December 22, 2020

Subject: CU-20-00004, Cruth Storage Units
I-90 MP 71.73 to MP 71.80 right – Exit 71 – Tree Farm Rd.

We have reviewed the proposed site plan and have the following comments.

Sheet Title  
**SITE PLAN**

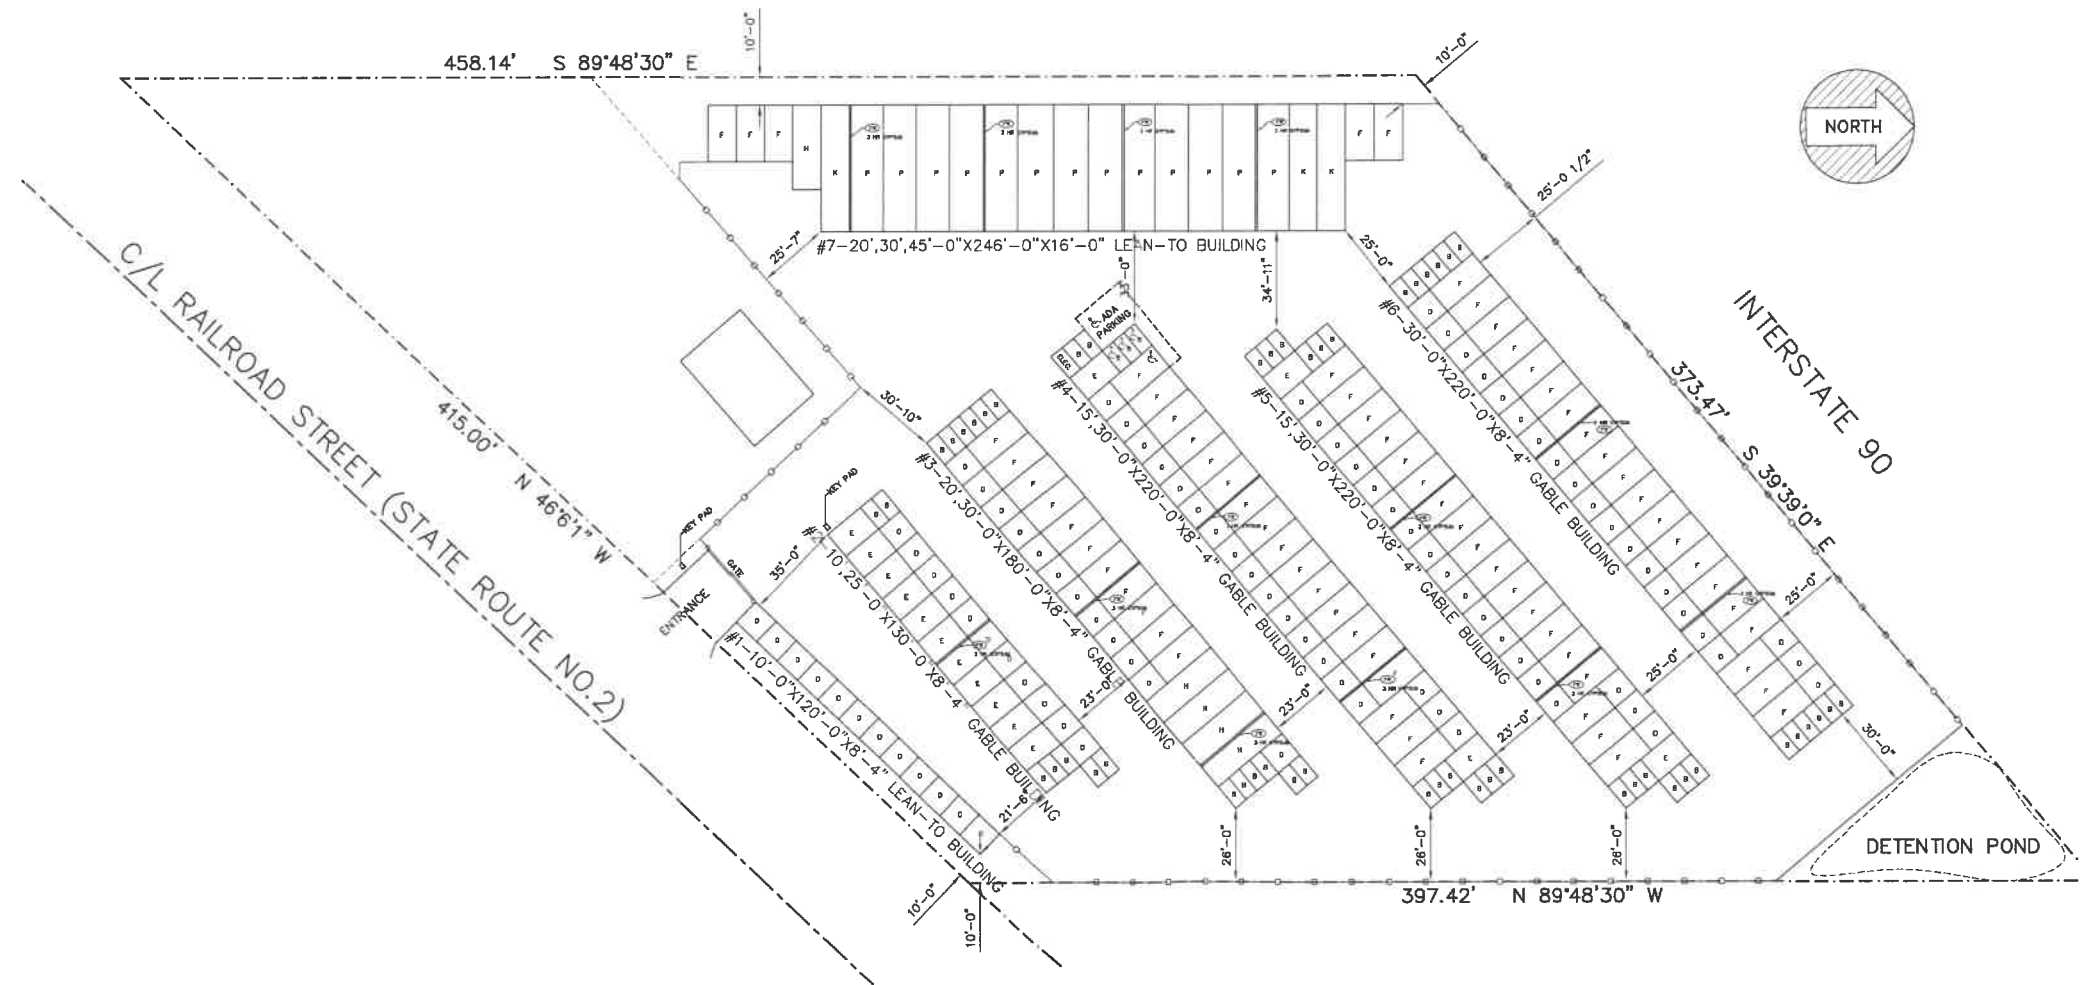
- The subject property is adjacent to Interstate 90 (I-90), a fully-controlled limited access facility with a posted speed limit of 70 miles per hour. WSDOT has acquired all access rights to the highway, including the on- and off-ramps of Exit 71. Direct access to I-90 or within the limited access boundary is strictly prohibited.

- Stormwater and surface runoff generated by this project must be retained and treated on site. Any discharge of stormwater into I-90 right-of-way will require an approved utility permit.

- Any snow accumulated on the property shall not be moved onto WSDOT right-of-way. We encourage the proponent to not underestimate the potential for large volumes of snow and designate a snow storage area on the property.

- Any proposed lighting must be directed down towards the site and away from I-90.
- Any outdoor advertising or motorist signing considered for this project will need to comply with state criteria. Please contact Trevor McCain of the WSDOT Headquarters Traffic Office for specifics. He can be reached at (360) 705-7282.

- The I-90 right-of-way fence typically lies one-foot inside our right-of-way boundary and must not be altered or moved.
